Your ref: SSD-8642

Mangoola Coal Continuation Operations Project (SSD-8642) – review of Response to Submissions Report

Mangoola Coal Continued Operations Project (SSD-8642) – Review of Response to Submissions Report

DIAGRAM: SSD 8642-001

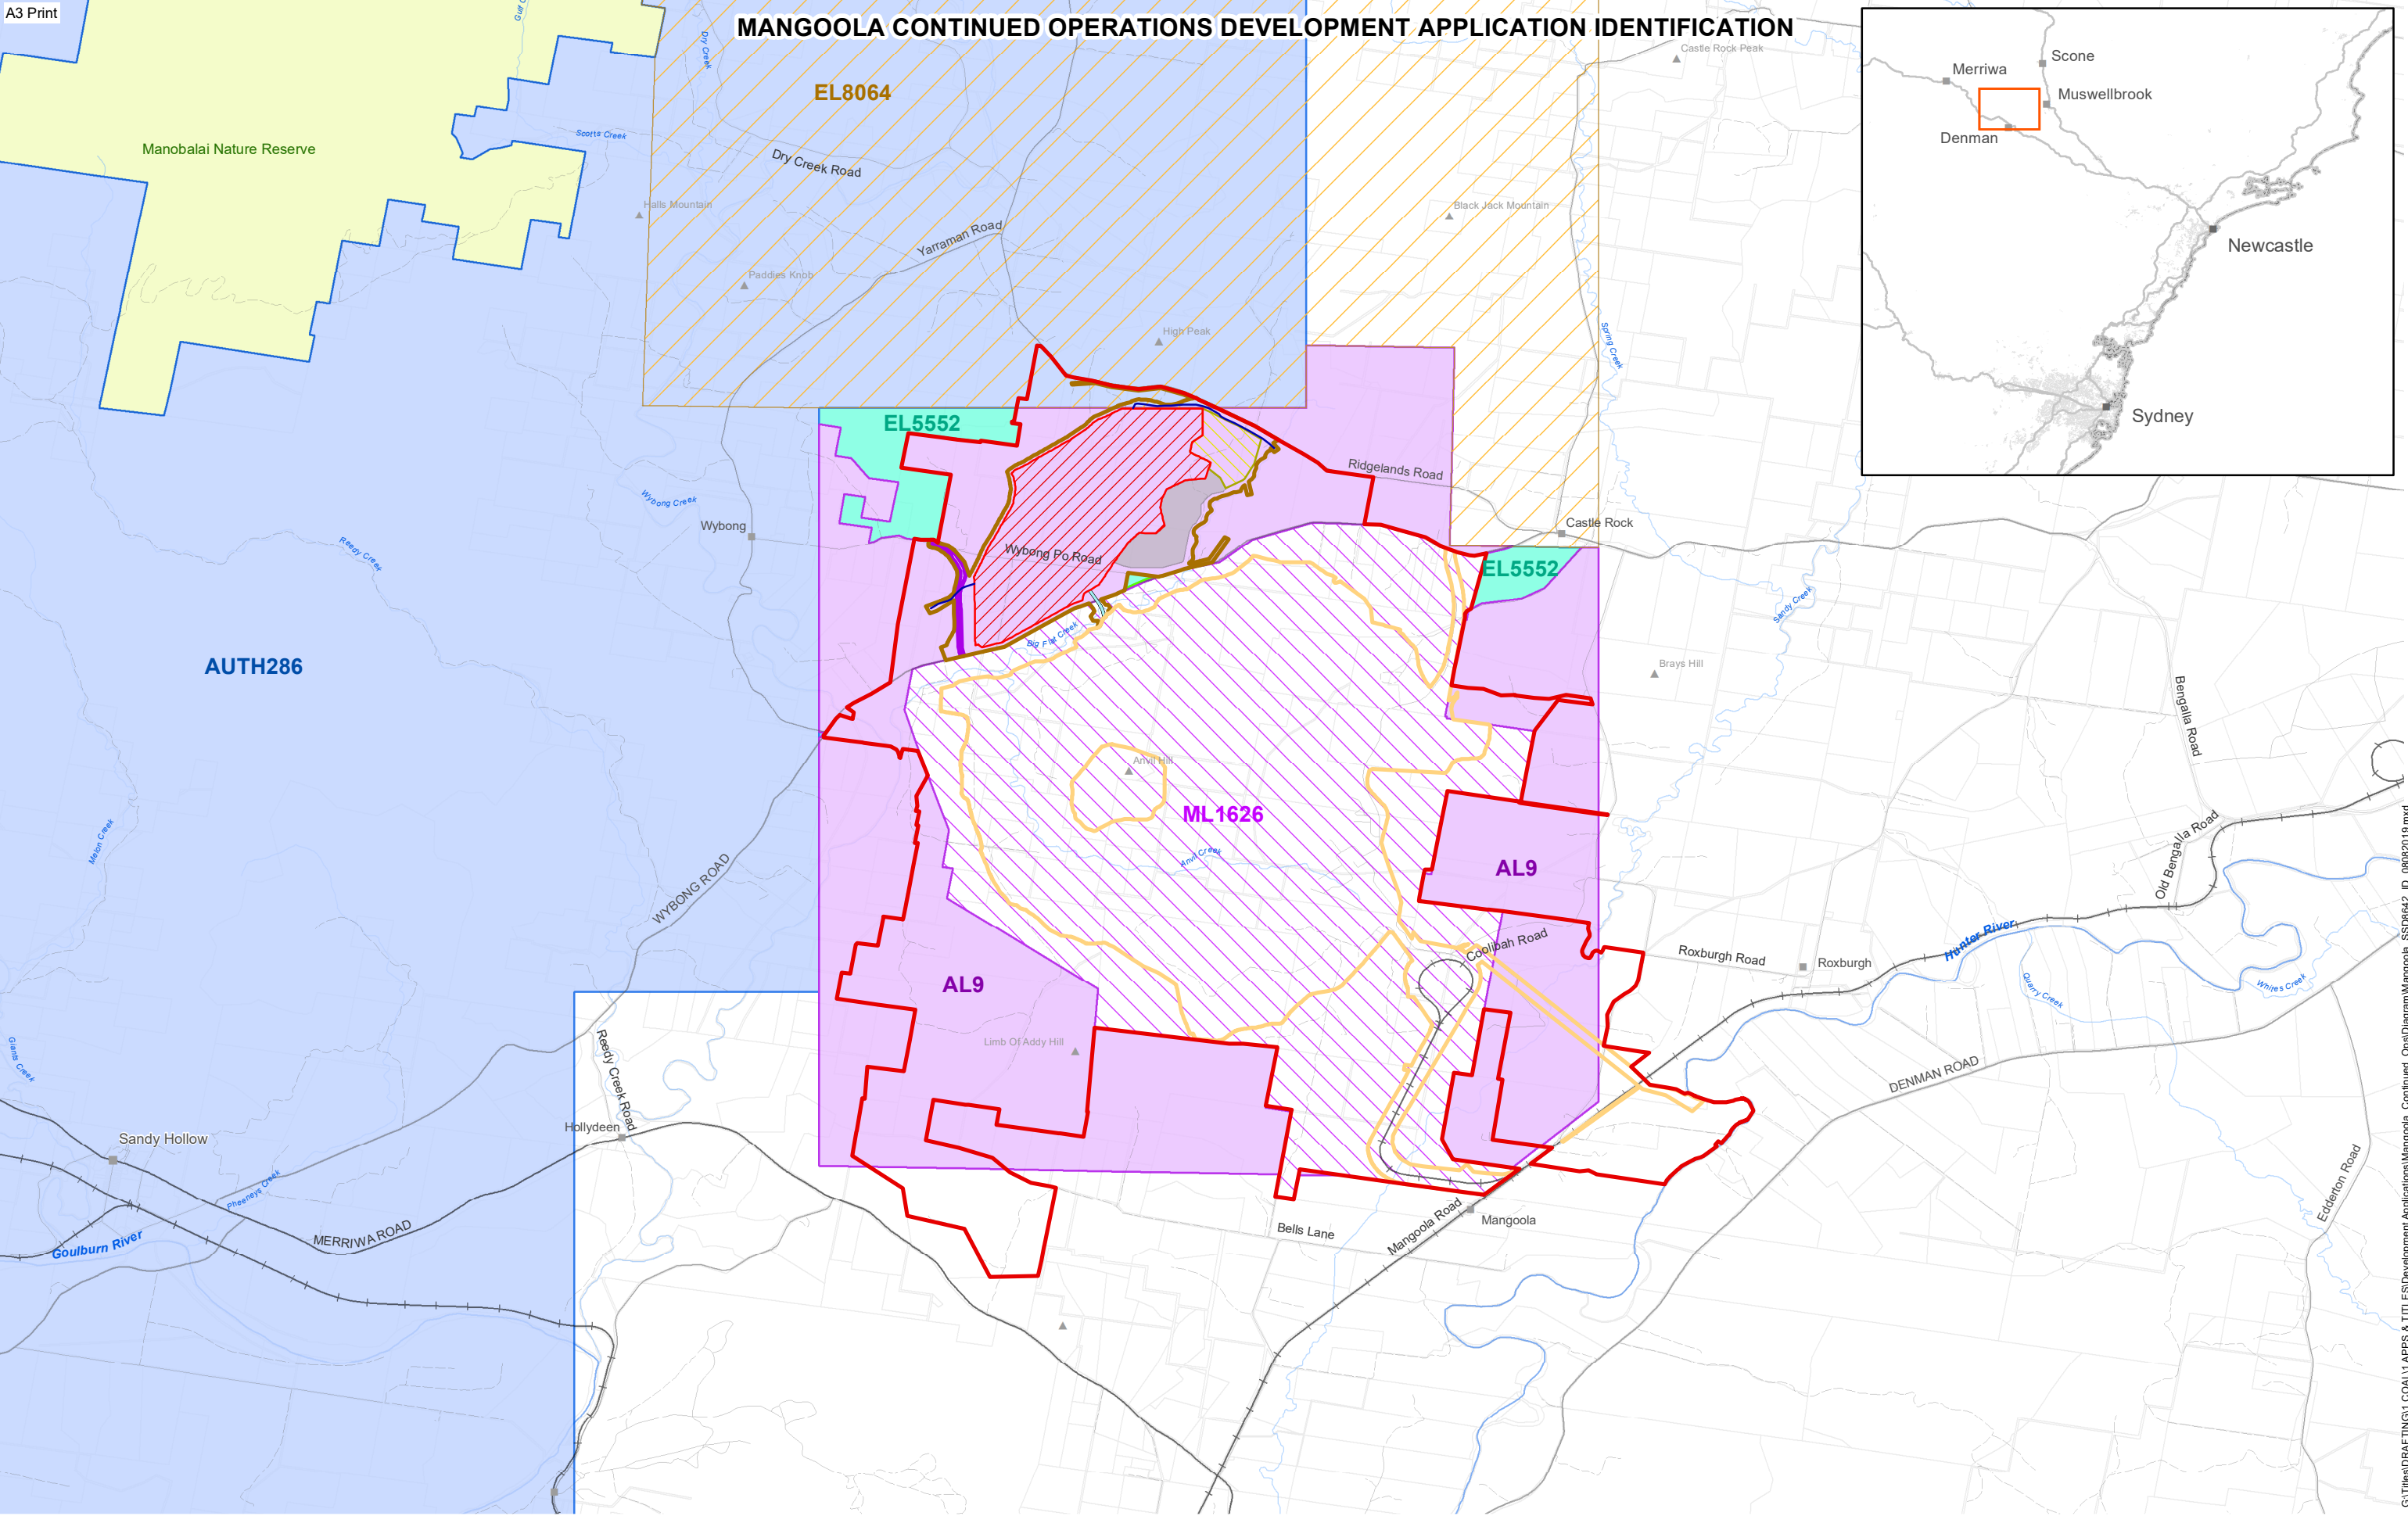
8. The project should not reduce the flood immunity of Wybong Road at the Wybong Road haul road overpass

Comment 18 in BCD's letter dated 5 September 2019 raised the issue of flooding behaviour beneath the proposed Wybong Road overpass and recommended that it be reviewed so the safety of the roadway during flooding is not affected by the project.

The proponent undertook a flood impact assessment to investigate this and included the assessment as Appendix 4 of the RTS. That assessment determined that flooding impacts to Wybong Road would remain relatively unaffected for the 1% Annual Exceedance Probability (AEP) flood event. During a 1% AEP event, flood depths on Wybong Road at the haul road crossing will be in the range of 550mm to 750mm (not passable for vehicles).

BCD notes that Wybong Road appears to remain passable by vehicular traffic for events up to 10% AEP. Flooding hazards on Wybong Road at the proposed haul road overpass will increase due to the project as it will result in a containment of flows in a confined space along the road corridor.

The detailed design of the Wybong Road haul road overpass should include additional drainage through the embankments. At a minimum, the flood immunity under the haul road crossing should not be less than then Wybong Road's current level of flood immunity, although this was not determined in the flood impact assessment. The proponent should determine Wybong Road's current level of flood immunity prior to adopting a design standard less than the 10% AEP flood event.

9. The flood hazard vulnerability classification along Wybong Road should not exceed H2 for the 10% AEP flood event

BCD note that the project will reduce Wybong Road's level of flood immunity. The most notable change is the flood hazard increases from a H2 hazard classification to H5 for a section of road near chainage 4,800 m. The H5 classification signifies a very high level of flood risk and is described as being unsafe for all vehicles and people during flood conditions. The change of classification caused by the project signifies a substantial increase in risks to users of Wybong Road. This risk would be particularly apparent for frequent users of the road, who may perceive a lower level of risk due to past experiences travelling on the road in flood conditions.

If the flood hazard classification at chainage 4800 still exceeds H2 after detailed design, the proponent should undertake appropriate measures to reduce the hazard, such as upgrading the culvert at the Big Flat Creek crossing.

Prior to construction, the Wybong Road haul road overpass should be designed to include drainage measures that ensure that the current pre-project flood immunity of Wybong Road is at least maintained or improved.

Prior to construction and as part of detailed design the proponent should implement appropriate mitigation measures to ensure that the flood hazard vulnerability along Wybong Road does not exceed H2 for the 10% AEP flood event.
